Letter of Intent

Site Information

13854 Gleneagle Drive
Colorado Springs, CO 90921
Size: Site - 2.72 Acres
Zone: R-4 (obsolete)

We request a proposed car rental office be approved for a variance of use within the current lot zoned as R-4.

PLOT
PLAN

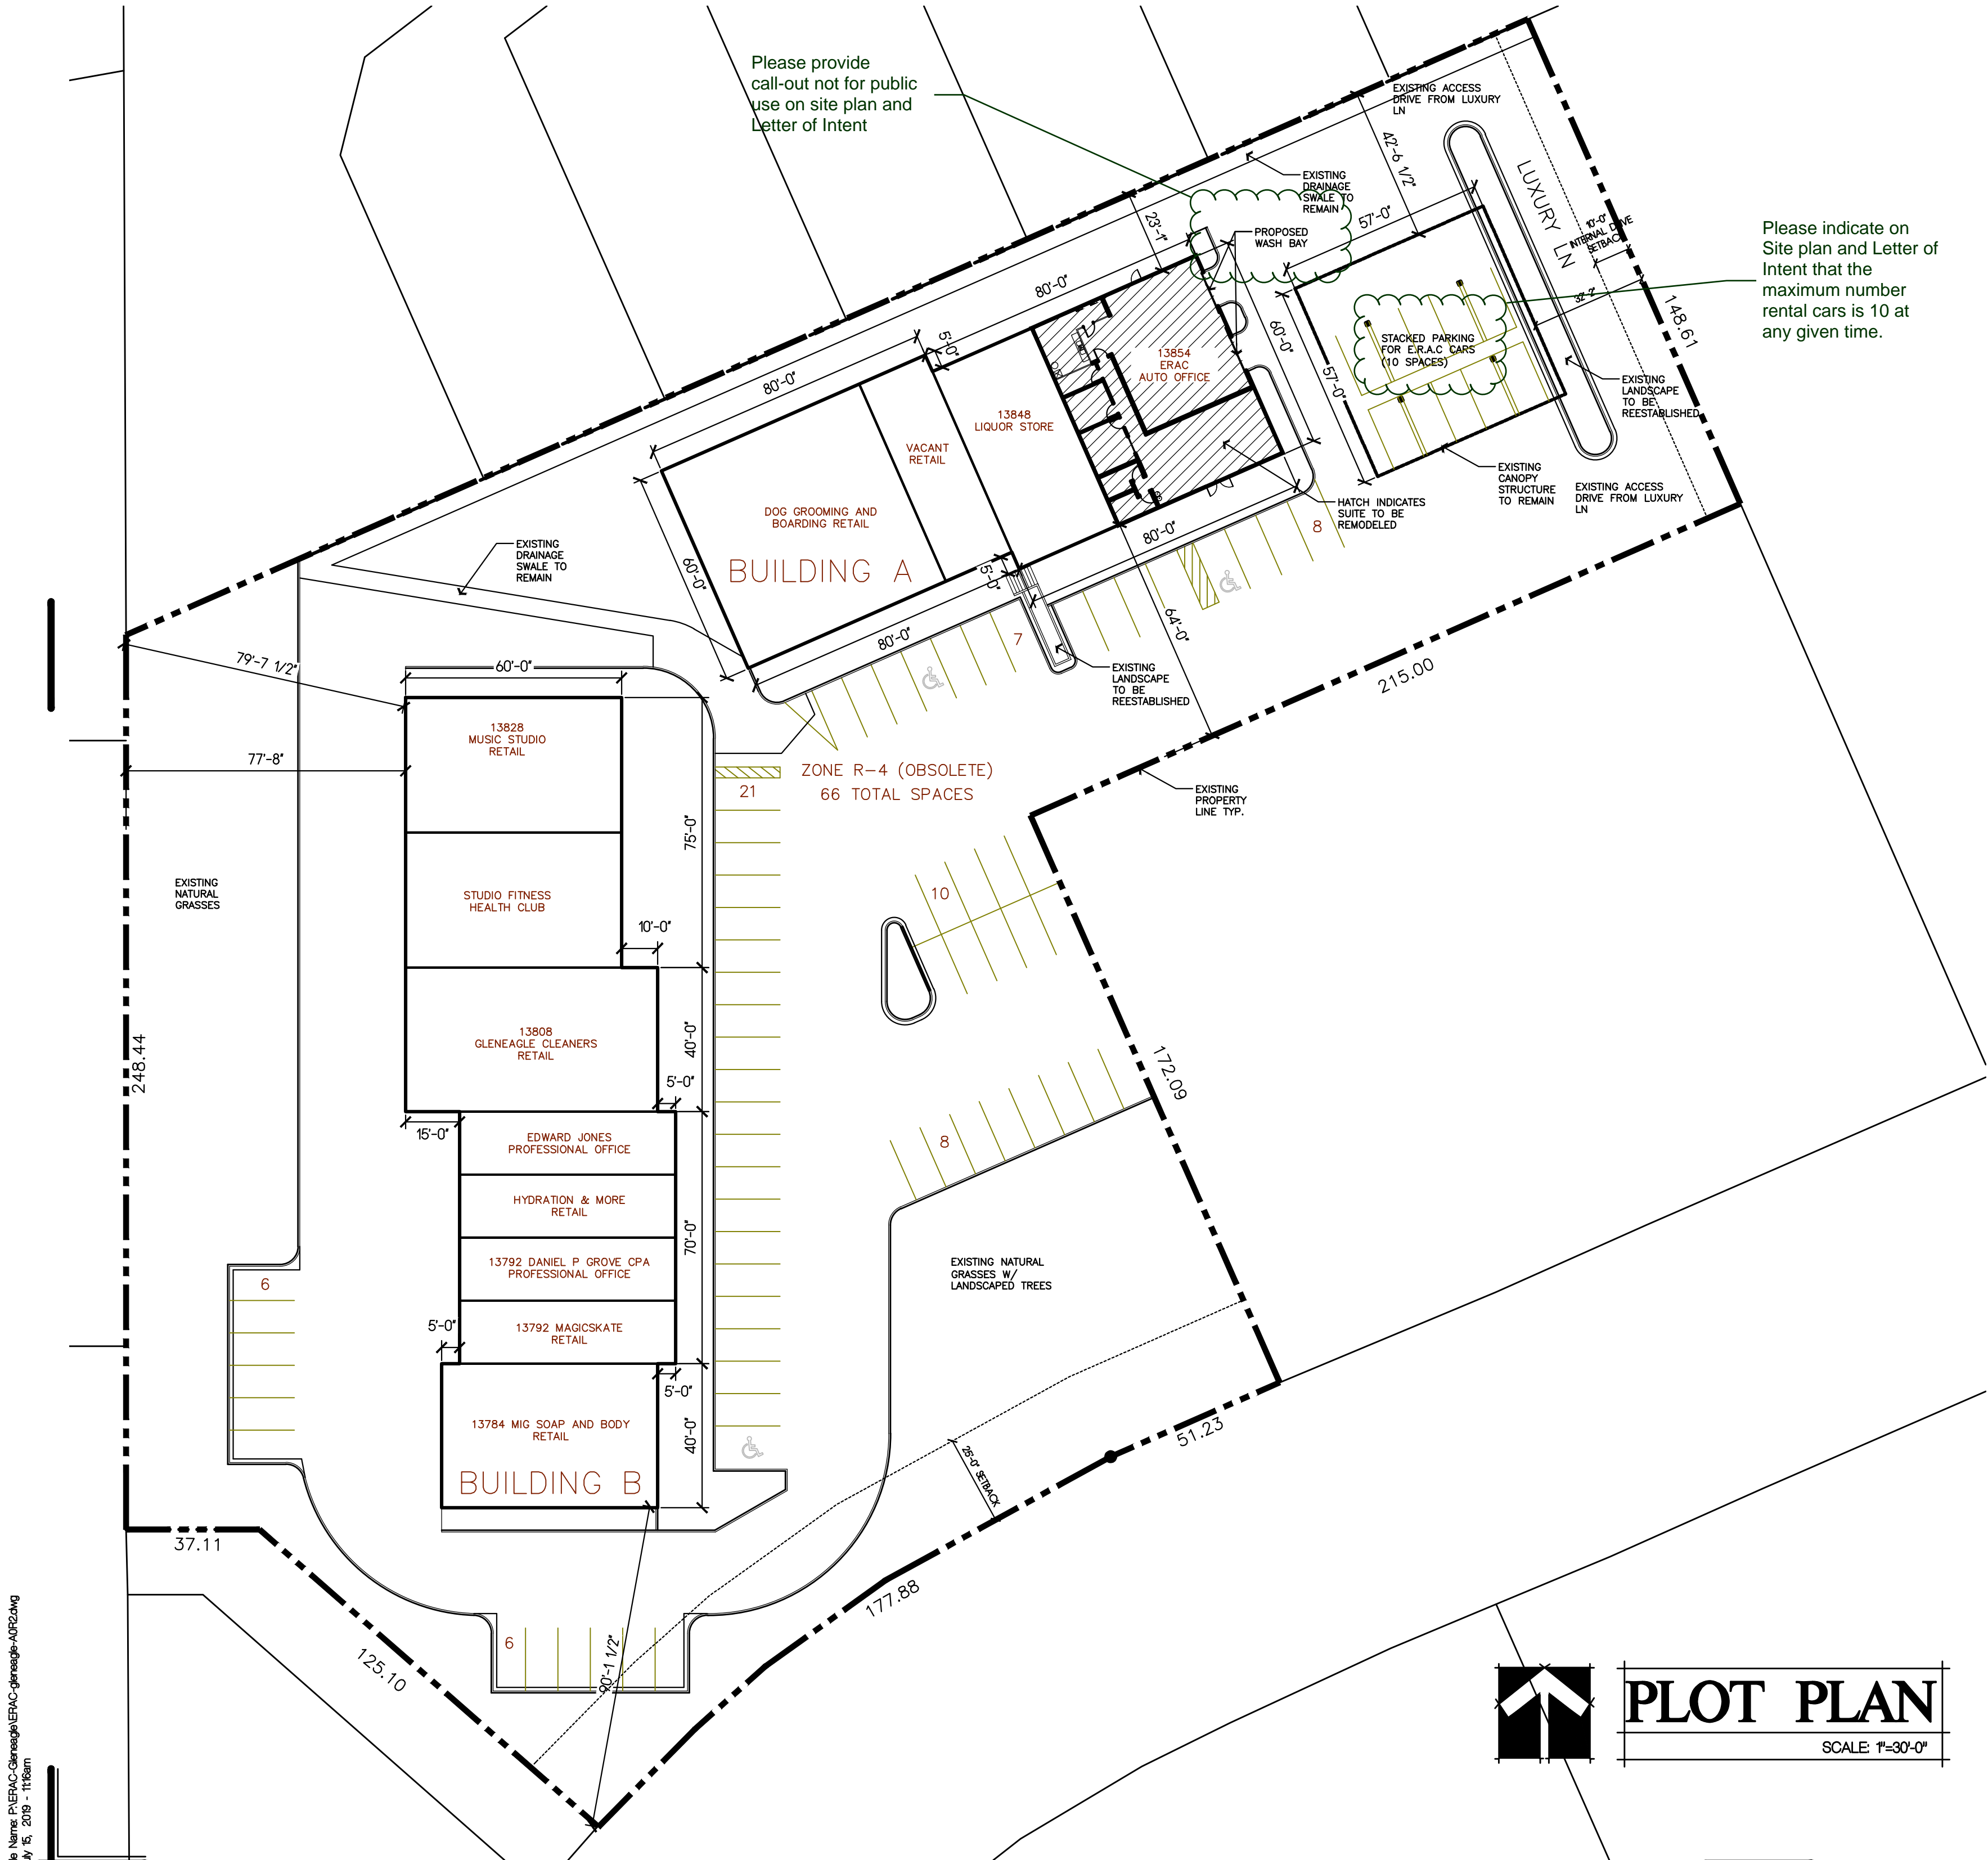
requires a landscape
plan

Not consistent with
above statement that
the site will be
analyzed then only
down fixtures will be
utilized.
